Ribble Valley Borough Council
Housing & Development Control

Application no: **3/2023/0384**

Address: **Honfleur 3 Grindleton View Chatburn BB7 4BE**

Proposal: **Proposed new 4 bedroom dwelling and creation of new access on land to the side of 3 Grindleton View.**

Date: 09/05/2023	Drawn by: JHolden
Scale: 1:100 @ A1	Sheet: 004
Client: Mr & Mrs Bradley	Revision: -

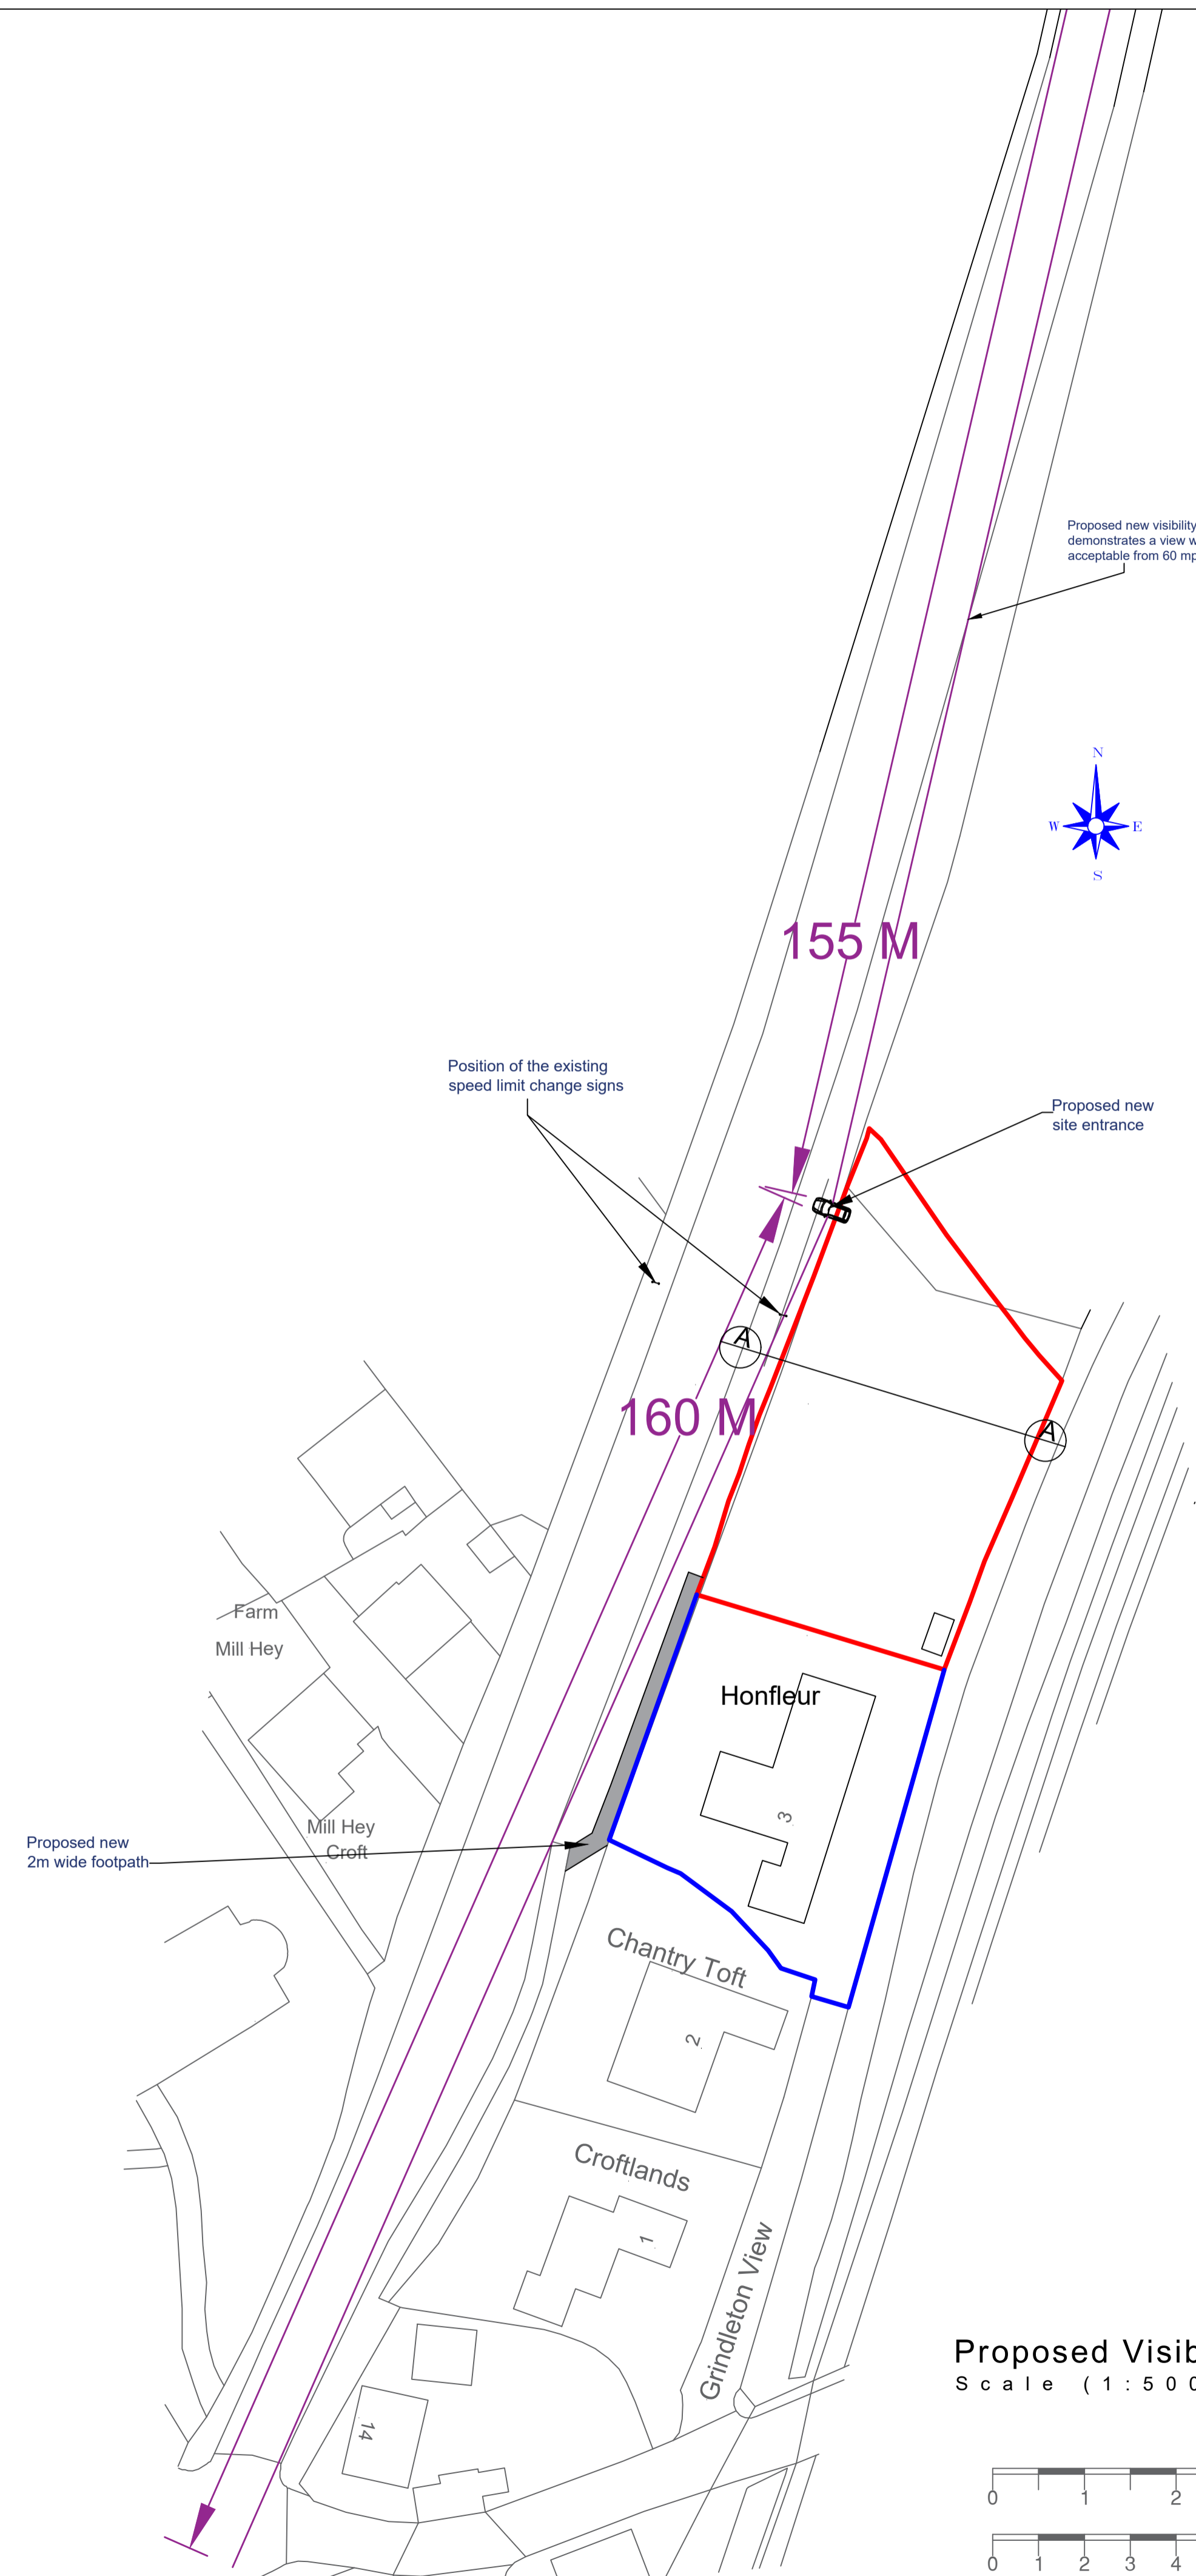
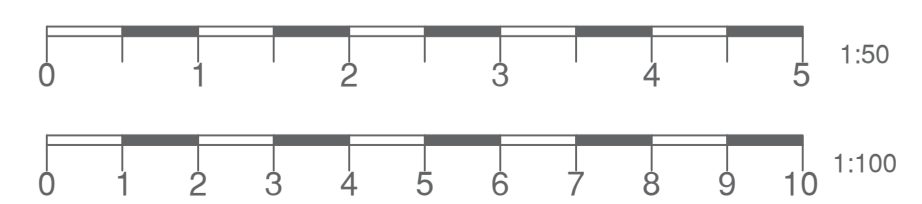
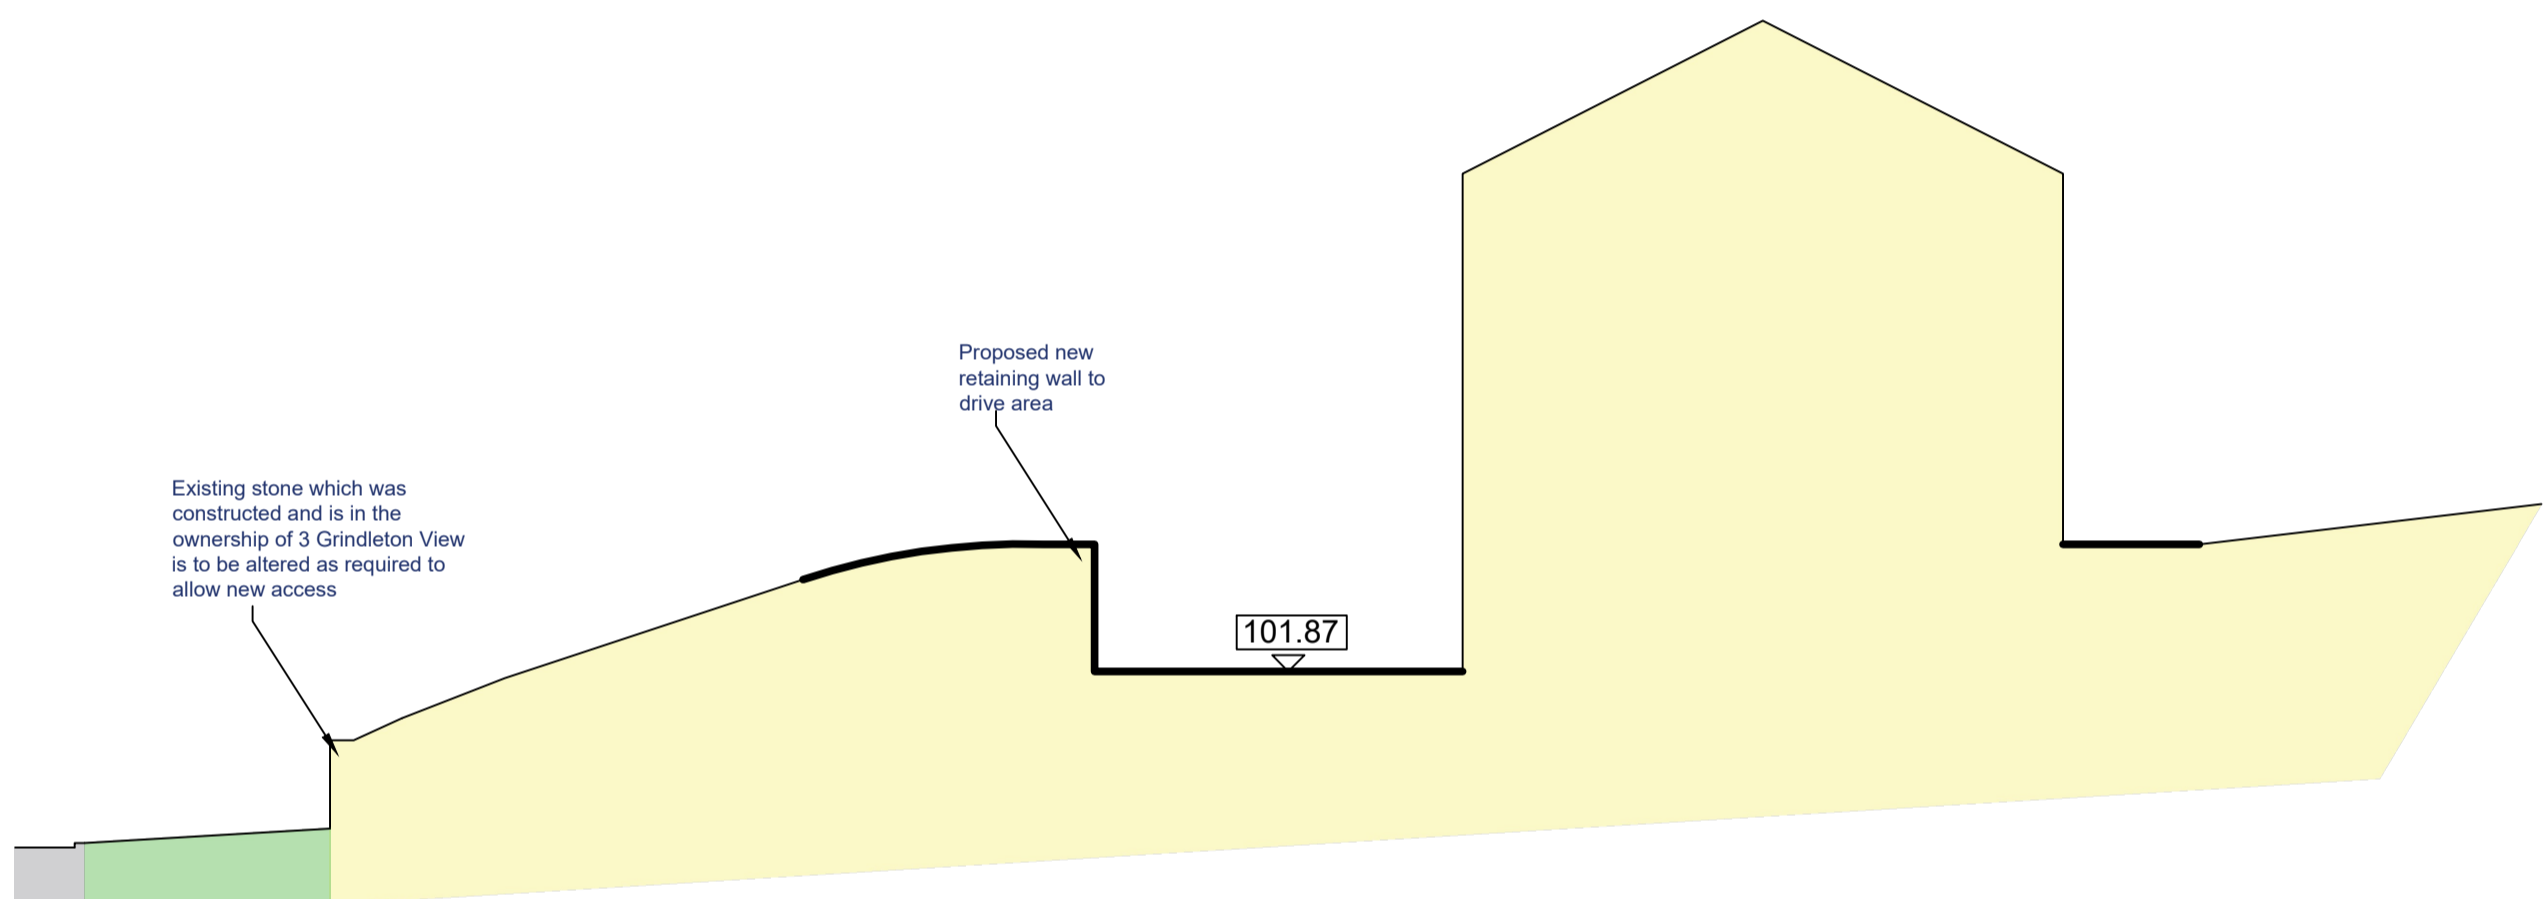
However, due to the site being in close proximity to two speeds limits, as mentioned above, the LHA will request that a traffic survey is conducted to determine the 85th percentile speeds within the vicinity of the site, which will enable the LHA to determine the minimum requirement for the visibility splays.

The LHA are aware that the Agent has provided on the drawing visibility splays of 2.4m x 160m to the north and 2.4m x 155m to the south. However, this does not comply with the LHAs visibility splay guidance for a 60mph speed limit, with the LHA requiring minimum splays of 2.4m x 214m in both directions. Therefore, even if the site wasn't in between two speed limits, a traffic survey is required.

The LHA have reviewed Holden drawing number 004 and are aware that a partial footway is provided which will connect to the existing southbound bus stop and will provide a link to Chatburn village centre. However, the new footway should start at the site access and then connect to the existing footway along Sawley Road. This should be shown on a revised plan and the footway should be a minimum of 2m wide.

The footway should also provide an uncontrolled pedestrian crossing via dropped kerbs and tactile paving connecting to the existing footway on the opposite side of the carriageway. This will provide a connection to the northbound bus stop which is located opposite the site.

As documented on Holden drawing number 004, the gradient at the proposed access will be approximately 1 in 11.43. This is acceptable but the LHA require site section drawings to be submitted to ensure this is consistent from the adopted highway into the site. The gradient should not exceed 1 in 10.
